From: Bowie, David [REDACTED]
Sent: 17 September 2021 11:07
To: Michael Eastham <Michael.Eastham@arun.gov.uk>
Cc: Cleaver, Elizabeth [REDACTED] Bown, Kevin
[REDACTED] Planning SE [REDACTED] Jackson, Andrew
[REDACTED] Welby-Everard, Christopher [REDACTED]
[REDACTED] Kevin Markey [REDACTED] David
Howson [REDACTED]
Subject: RE: Alternative Access Tye Lane Walburton WA/63/21/PL

Council's Reference: WA/63/21/PL

Location: Land East of Tye Lane Walberton BN18 0LU.

Proposal: Proposed alternative vehicular accesses off Tye Lane and emergency access off Avisford Park Road, along with minor highway works following WA/95/18/RES (resubmission following WA/93/20/PL). This site is CIL Zone 2 (Zero Rated) as other development.

DRAWING TITLE
Combined Tree Retention/Removal & Protection Plan - Access Arrangements

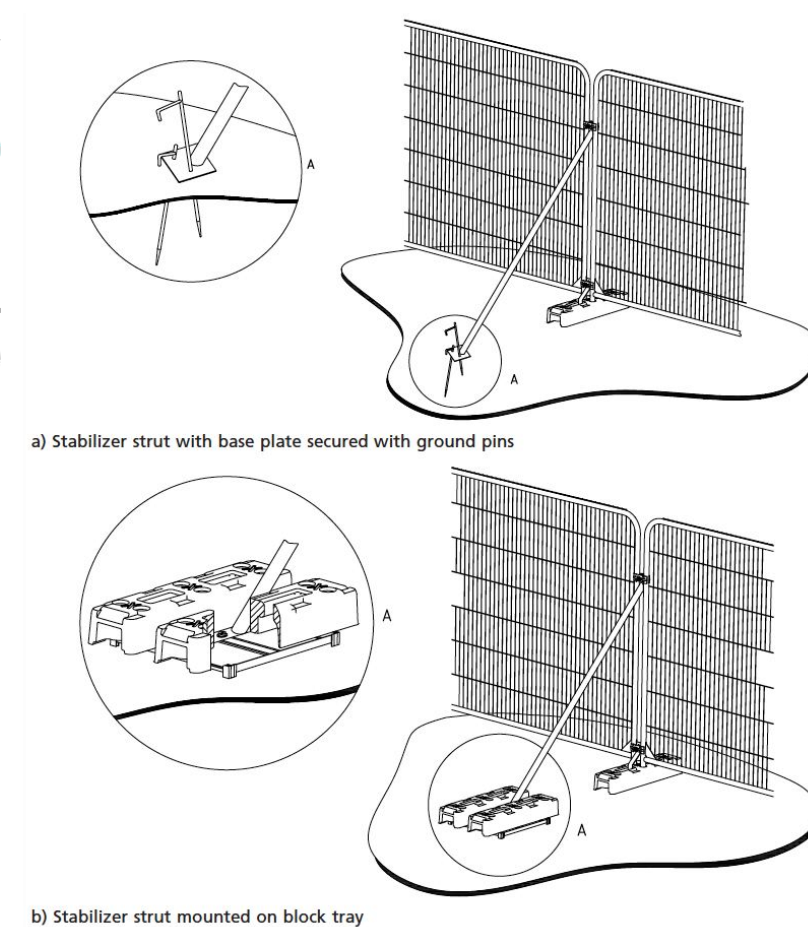
- In respect of the ditch excavations works and the close presence of the TPO trees, we would recommend that exploratory air spade works are carried-out along the length of the ditch, under the supervision of the appointed arboriculturalist, particularly to the south of the proposed access to establish if any major roots are present within the extent of the proposed excavation.

- Once air spade exploratory works are complete, the extent of potential impacts can be thoroughly evaluated and any amends to the ditch proposals made accordingly or where root pruning is the only viable option, an approach agreed in partnership with the LPA tree officer and set-out in a detailed Arboricultural Method Statement.

- Once the final scheme is agreed, works to form the new ditch should continue to be undertaken through a combination of both air-spade works and hand-digging, all of which should be undertaken under the supervision of the appointed arboriculturalist.

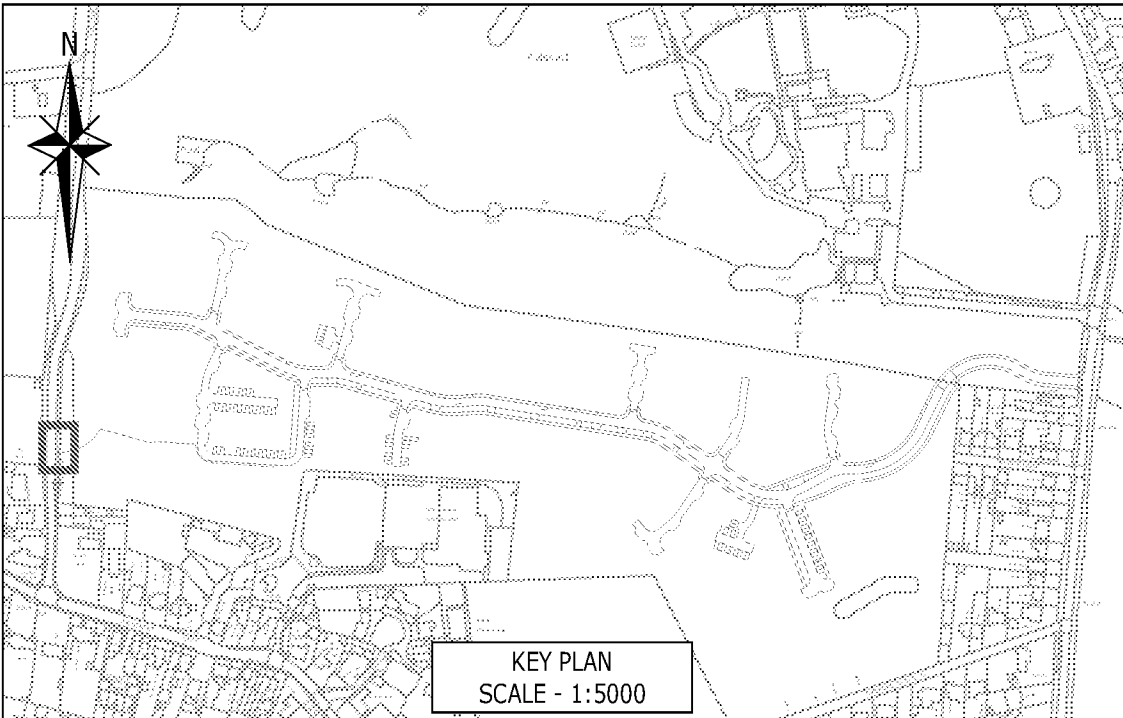
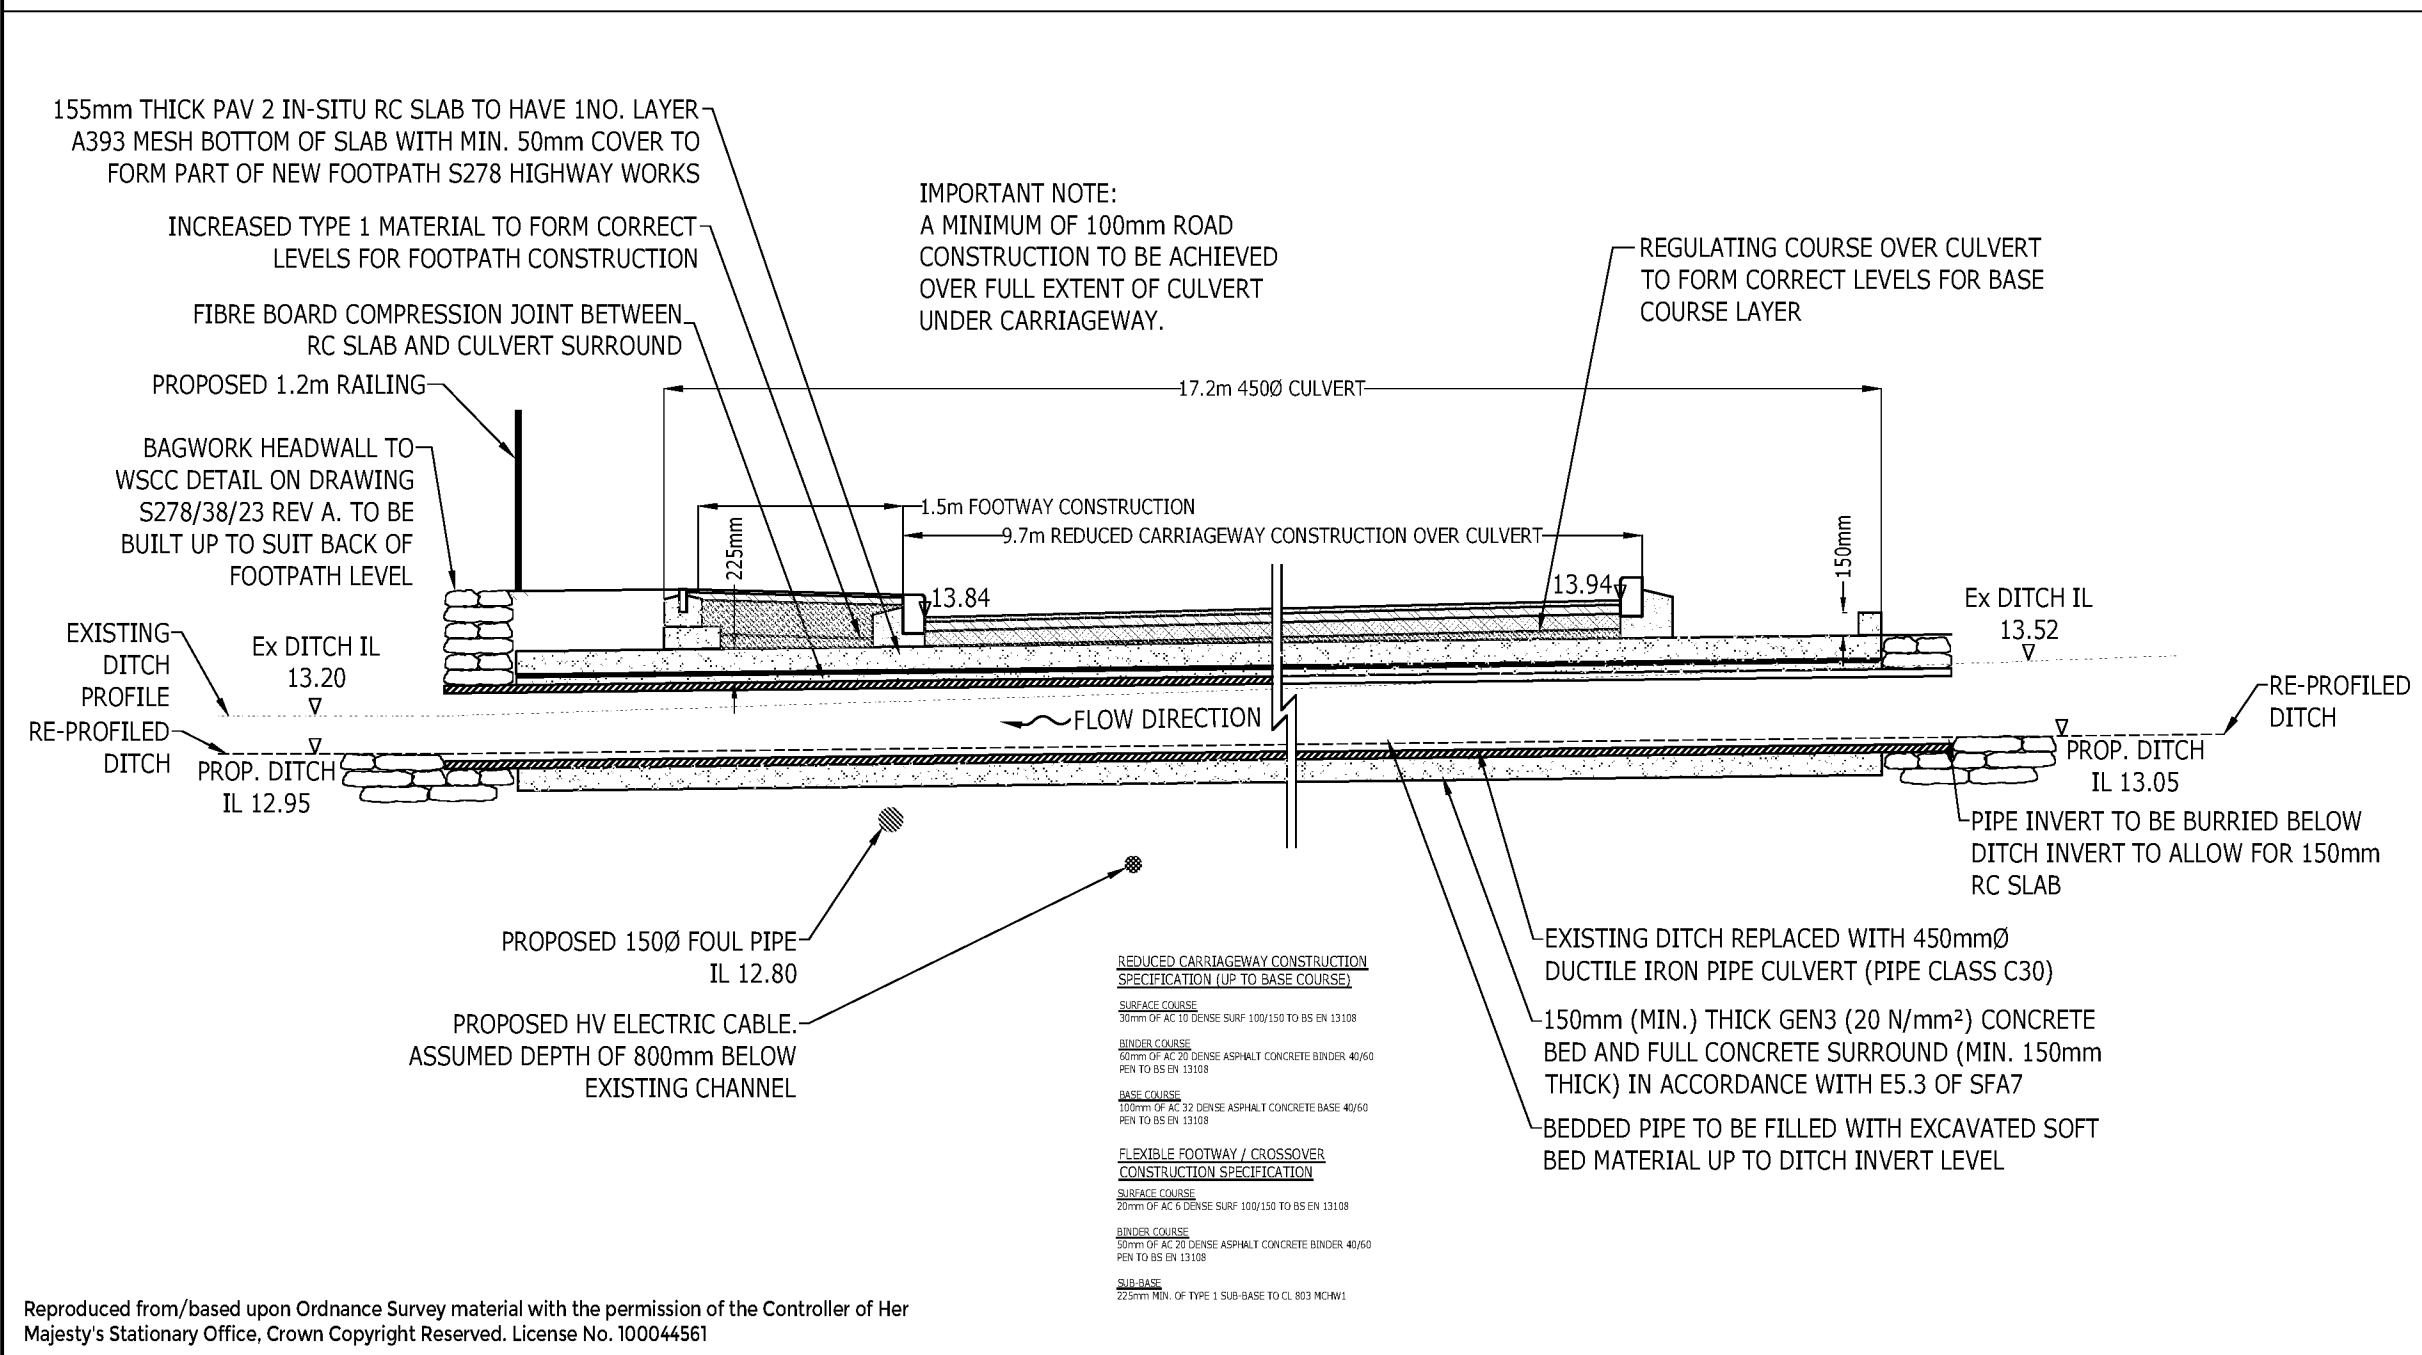
- *Comment 1 (Culvert invert level vs the foul pipe invert level):* As the foul pipe is part of the proposed works we have the ability to lower the foul pipe invert to provide greater clearance to the culvert. Given the downstream connection invert, we would be able to lower the proposed foul pipe by over one metre.

- *Comment 2 (Ability to deepen the watercourse given the constraints that exist):* Pending further investigation to determine the presence of tree roots, the supplied drawing demonstrates that from a levels perspective, the proposed culvert and ditch realignment can be achieved.

- *Comment 3a (The proposed cross-sections are narrower than existing, leading to a loss of capacity):* The proposed ditch bed width is 0.5m, this is only 88mm narrower than the existing bed width at the upstream end of the proposed works. Any loss of capacity is more than compensated for by the proposed deepening of the ditch and the resulting increase in cross-sectional area. This is evident in the table below which compares the existing and proposed cross-sectional areas in all three sections shown on drawing 183248-001:

- *Comment 3b (Steep side slopes will lead to erosion and collapse):* The long term stability of the ditch will be considered during detailed design. If necessary for erosion protection, we would opt to use a proprietary slope stabilisation product which allows vegetation growth. One such solution is EnkaMat which has been used with great success on previous projects and promotes strong vegetation growth for permanent erosion protection.

- *Comment 3c (Works within the tree root protection areas):* [Insert advice from CSA]. If the further investigative works reveal the presence of significant tree roots within the area of the realigned ditch, we would recommend a lengthening of the culvert to avoid damage to the tree roots. This option would entail significantly less excavation.
